CITY OF ALBUQUERQUE

August 4, 2017

RE: **Campbell Compound**
Drainage Report and Grading Plan
Engineer's Stamp Date 7/21/17
Hydrology File: G13D032

CAMBELL SUBDIVISION			
LAS VENTANAS NM, INC.			
GRADING & DRAINAGE PLAN			
Date:	No. Revision:	Date:	Job No.
Sept 2017			2224
Drawn By:			G-13
ANW			
Ckd By:			SH 1 of 2

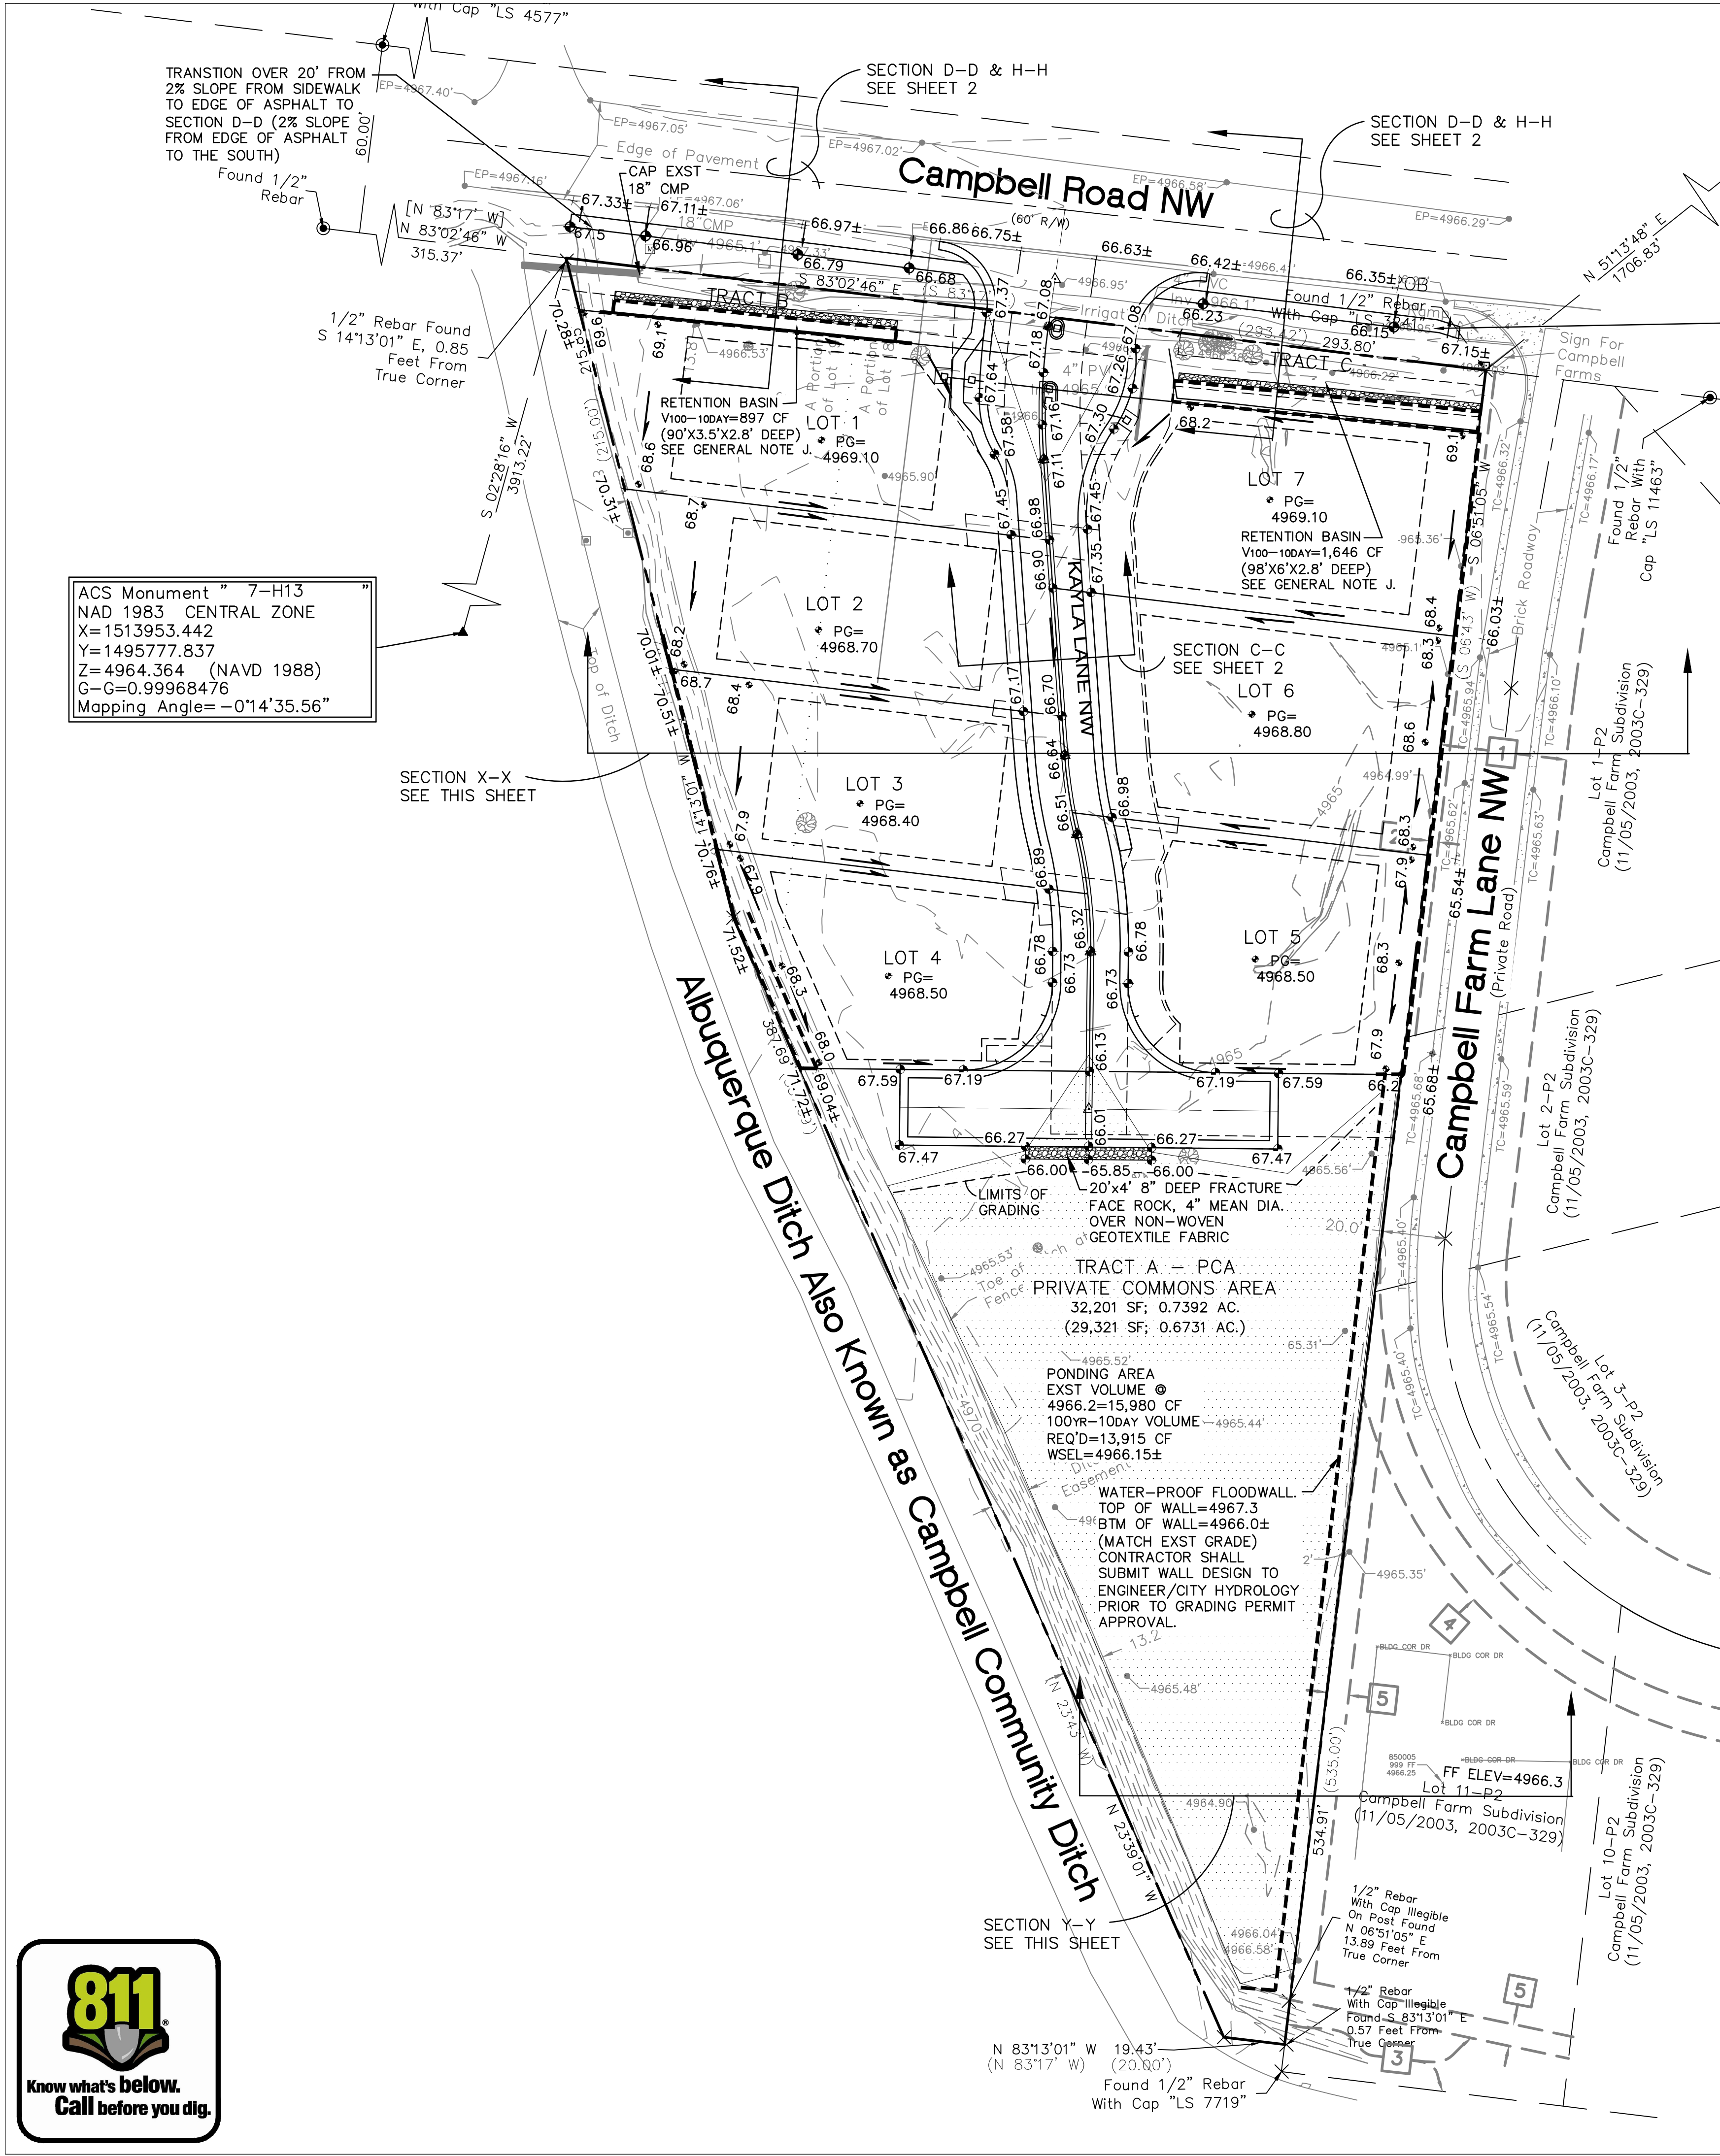
1. It appears that the Maximum Water Surface Elevation (MWSE) in the commons area pond will be higher than the adjacent Campbell Farm subdivision:
 - 1.1. Extend topography into the Campbell Farm subdivision and include Campbell Farm Lane, Lot 11 topo and finished floor.

- 1.2. Provide a section view through the pond (including the MWSE), property line and onto lot 11 of Campbell Farm subdivision.
 - 1.3. The pond will need to be excavated to contain the MWSE below the adjacent subdivision with freeboard (1ft below the Campbell Farm Lot 11 finished floor).

2. Existing and proposed drainage along Campbell Rd.
 - 2.1. The existing drainage appears to sheet flow off the south half of Campbell into a roadside swale that ponds until eventually infiltrating. The existing farmstead is lower now and does not drain at all into the Campbell Rd ROW.

- 2.2. Provide a ponding area along the cottonwood row capable of maintaining the 10day, 100yr MWSE below the sidewalk and at least 1ft below the finished floors on lot 1 and lot 7.

- 2.3. The proposed drainage from Basin A can be held in the cottonwood row ponding area or be diverted south to the commons area pond. The south half-street of Campbell Rd should be able to sheet flow into the cottonwood row. Attempting to convey flows east on Campbell Rd in curb and gutter would lead to more ponding on the road between the entrance of Campbell Farm Ln and the Griegos Drain.

- 2.4. Provide a proposed road section for Campbell Rd and tract B/C. This should also incorporate the traffic requirements for frontage improvements.
- 2.5. The valley gutter in across the Kayla Lane entrance likely won't convey flows with this scheme and can be removed.

- 2.6. A 10' transition section will be needed to connect to the Campbell Farm frontage that lays down the standard curb and gutter and lowers the sidewalk to suit this project's frontage.

- 6.1. Raising the grade in this subdivision will put it several feet above the Campbell Farms subdivision. Ensure no drainage will exit this project site and impact this adjoining subdivision.
- 6.2. Include a section view though the property line between Campbell Farm Rd and the Campbell Compound east lots.
- 6.3. The backyard walls and footers (Section B-B) will need to be wholly contained on this project's property, unless written concurrence can be provided by the adjoining property owners for common walls.
- 6.4. Show the property line, section cut, and dimensional data for the double retaining wall.
- 6.5. Provide additional dimensions on the wall sections: max height retained, max privacy wall heights, and offsets.

- 6.6. Increase the slope and specify a minimum depth at flowline along the backyard walls; clarify the typical lot grading detail to show the backyard drains to the front (Kayla Ln) and no cross lot drainage or drainage through the backyard wall occurs.
7. Are any easements required for the ditch and will they conflict with the pad or wall locations?
